Great North Road Solar and Biodiversity Park - Project EN010162

Issue Specific Hearing 1 - JPAG

Summary Record of Oral Submissions of Anthony Northcote on behalf of JPAG

**Provisional Agricultural Land Classification Wider Area
Figure 17.2**

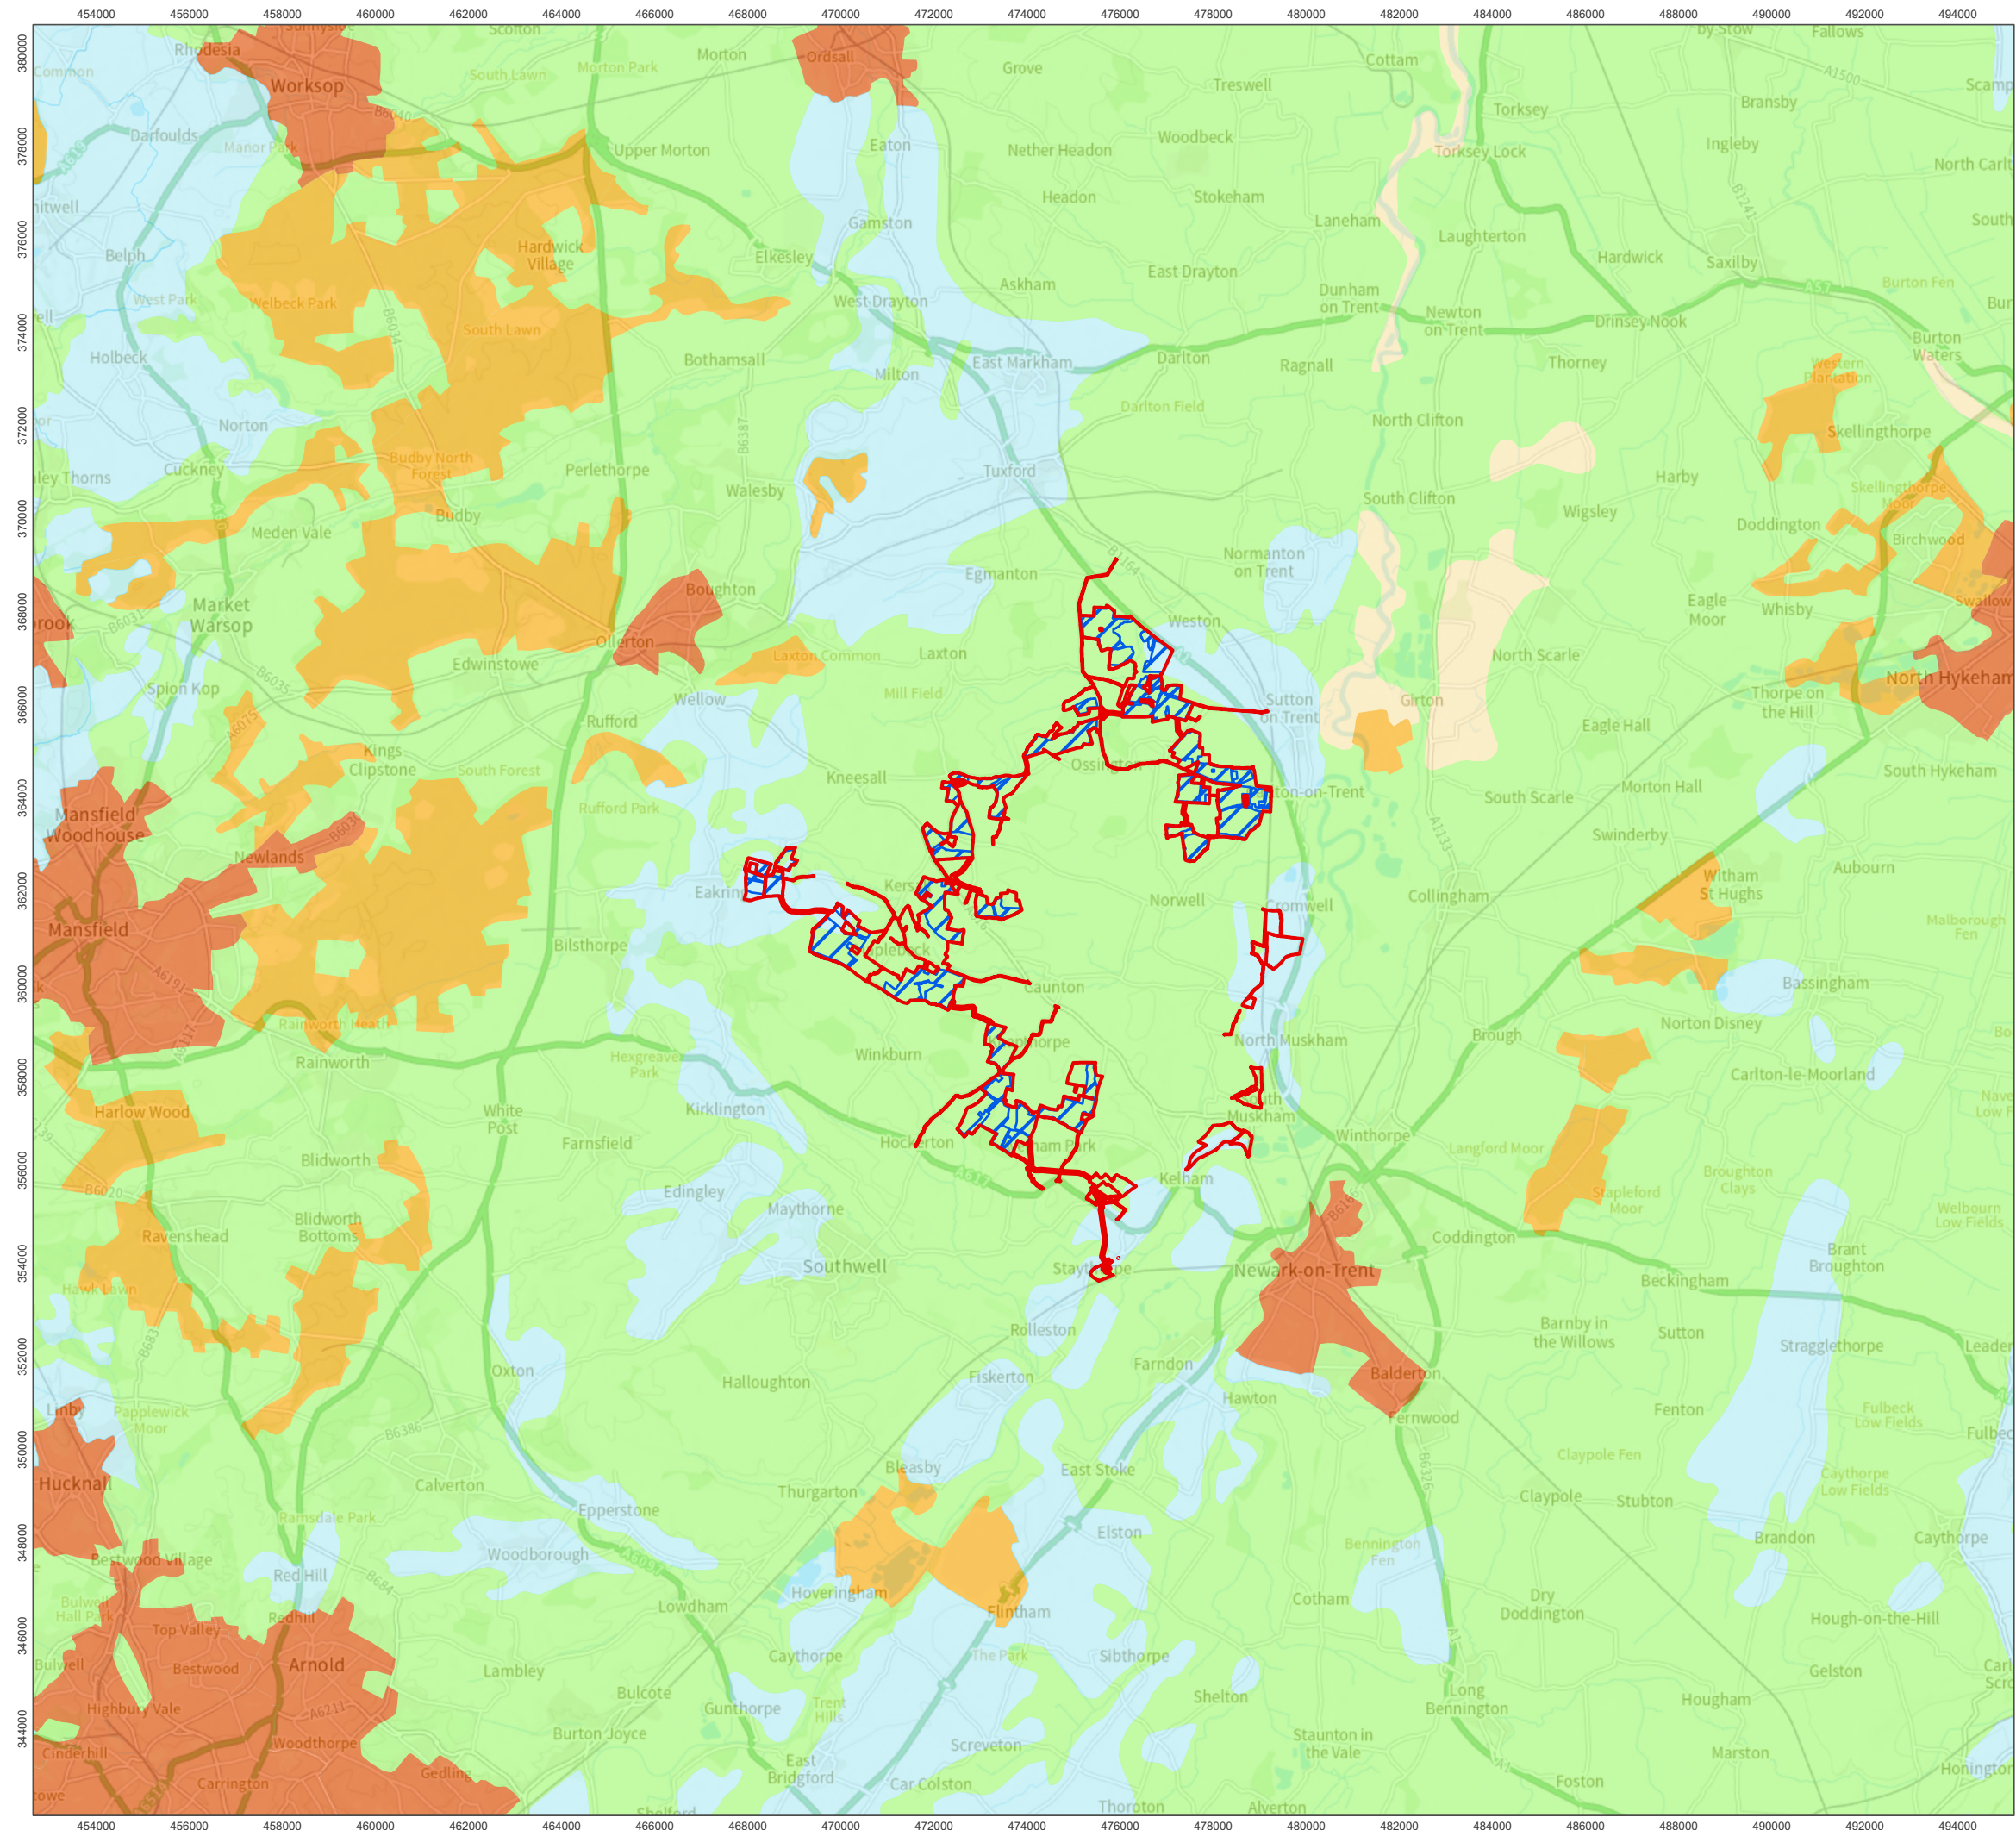
I had many of the same points that Newark and Sherwood raised, so I won't repeat them. It is necessary to take into account the written ministerial statement, which says, in addition to the two national policy statements, you should be avoiding BMV in the site selection process. The BMV figures are in table 17.5 of the environmental statement, which is App-060. Then if you also look at figure 17.1 in the agricultural land classifications APP-079, there you'll see that it's 149 hectares (8.5%) is grade 2, 944 hectares (53.5%) is grade 3A. If you look at the detail in figure 17.1, you'll see a lot of the grade 2 land in certain areas is where solar is proposed.
